CITY OF PORTLAND

BUILDING PERMIT

Located At 194 YORK ST

has permission to rebuild rear deck - 28' x 8'

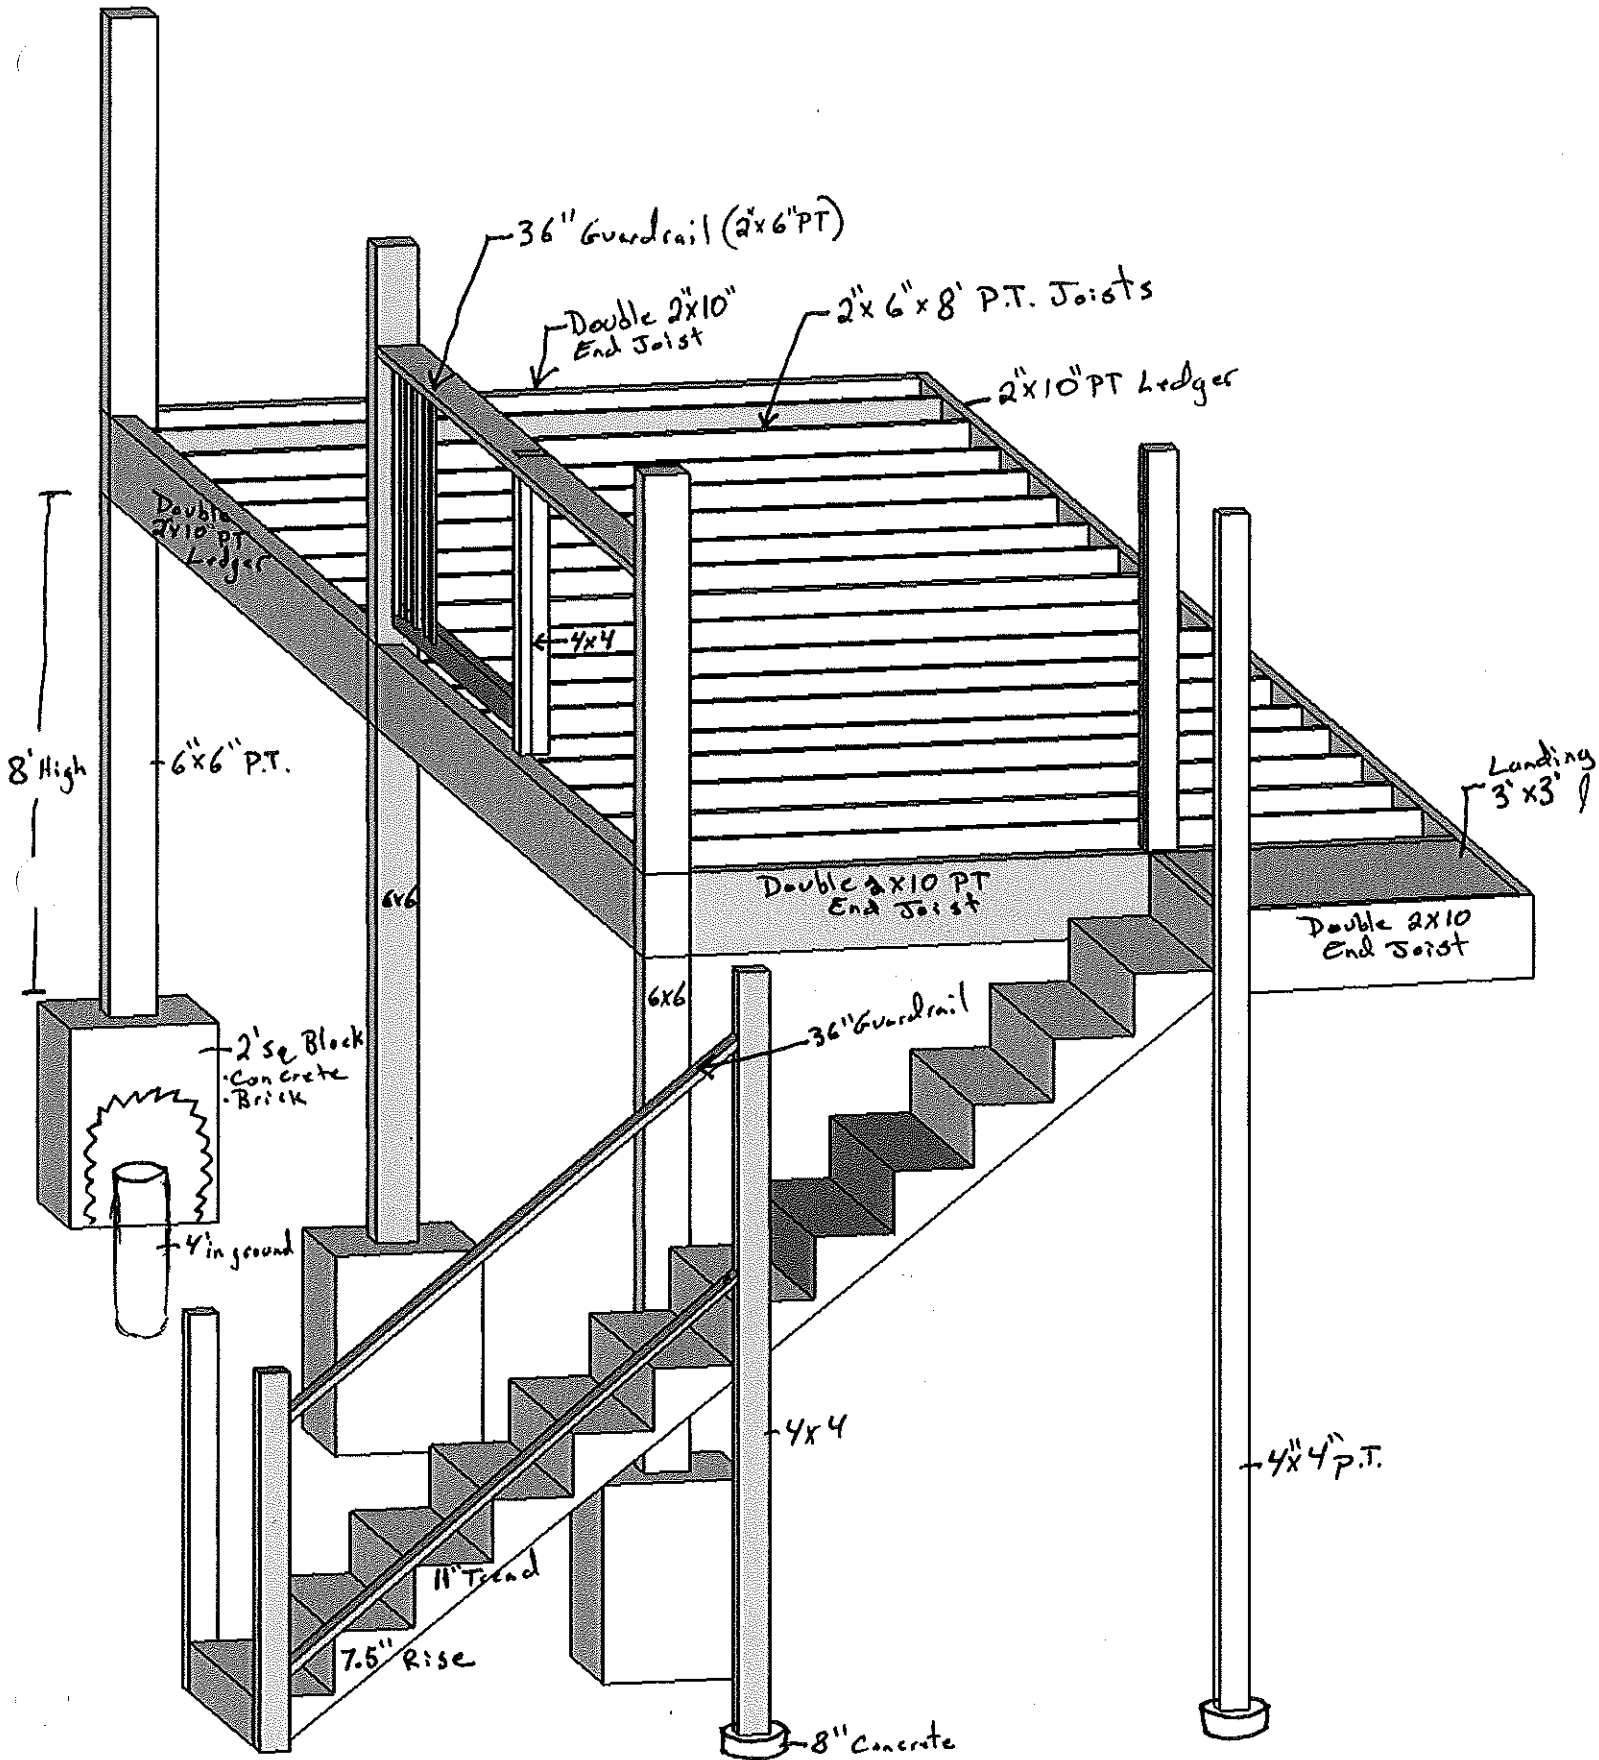
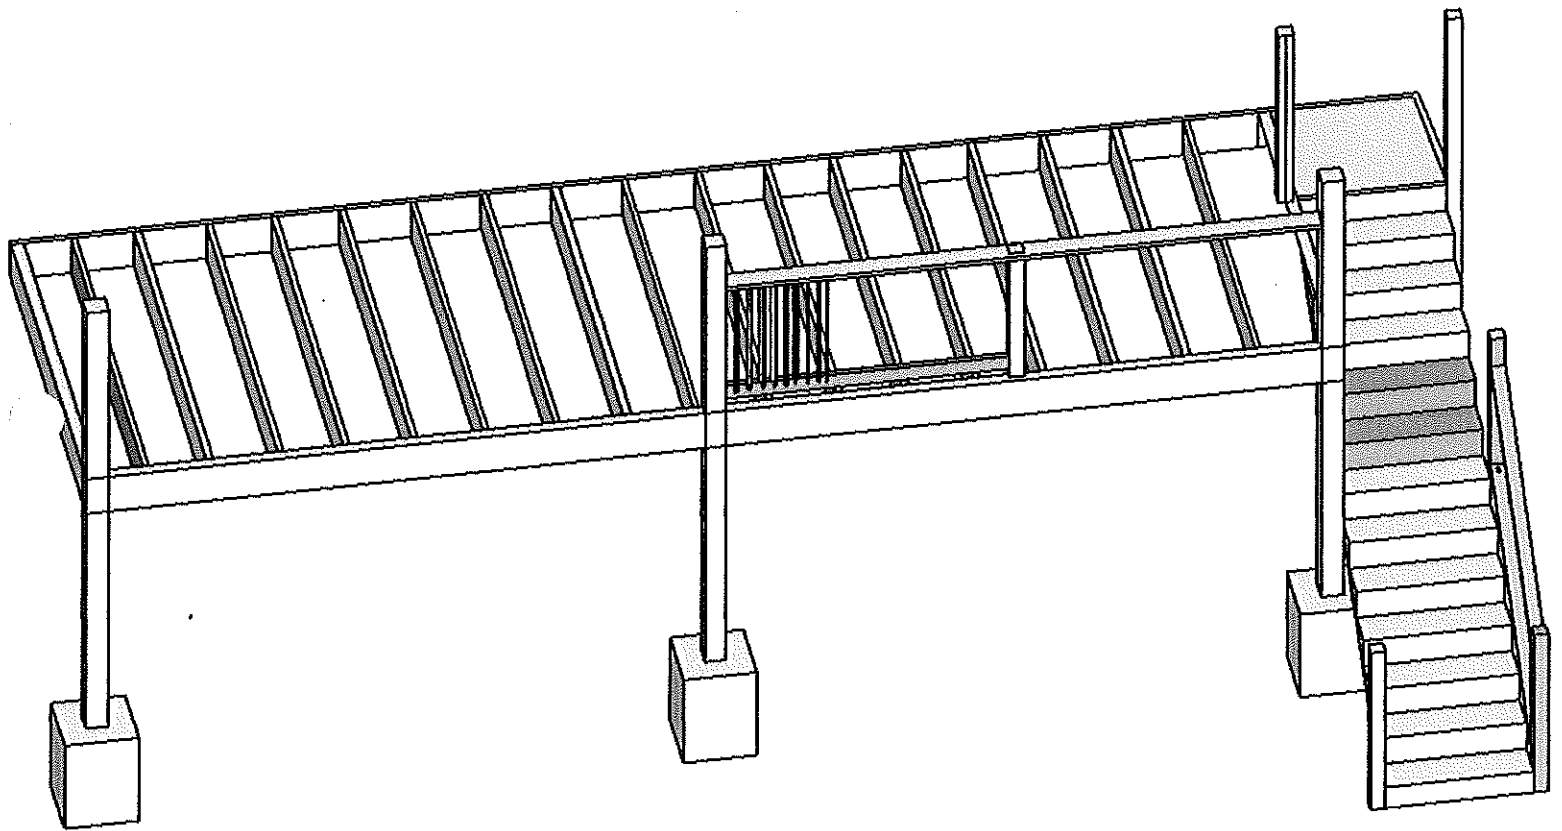
2. The maximum riser height shall be 7 3/4 inches; the minimum tread depth shall be 10 inches.
3. A graspable handrail (34-38 inches in height) shall be provided on at least one side of each continuous run of treads or flight with four or more risers. Fall protection (36 inches) from exterior decks may be required if floor joist are at or above thirty (30) inches from grade.

4. R311.5.1 Attachment. Exterior landings, decks, balconies, stairs and similar facilities shall be positively anchored to the primary structure to resist both vertical and lateral forces or shall be designed to be self-supporting. Attachment shall not be accomplished by use of toenails or nails subject to withdrawal.

5. **R502.6 Bearing. The ends of each joist, beam or girder shall have not less than 1.5 inches of bearing on wood or metal and not less than 3 inches on masonry or concrete except where supported on a 1-inch-by-4-inch ribbon strip and nailed to the adjacent stud or by the use of approved joist hangers.**

6. R502.5 Allowable girder spans. The allowable spans of girders fabricated of dimension lumber shall not exceed the values set forth in Tables R502.5(1) and R502.5(2).

7. Note: Owner is providing an additional Sona® Tube to allow a max span of 7 foot 3 inches for the (2) 2 by 10 inch beam. He will also provide four foot frost protection under the stairwell landing.
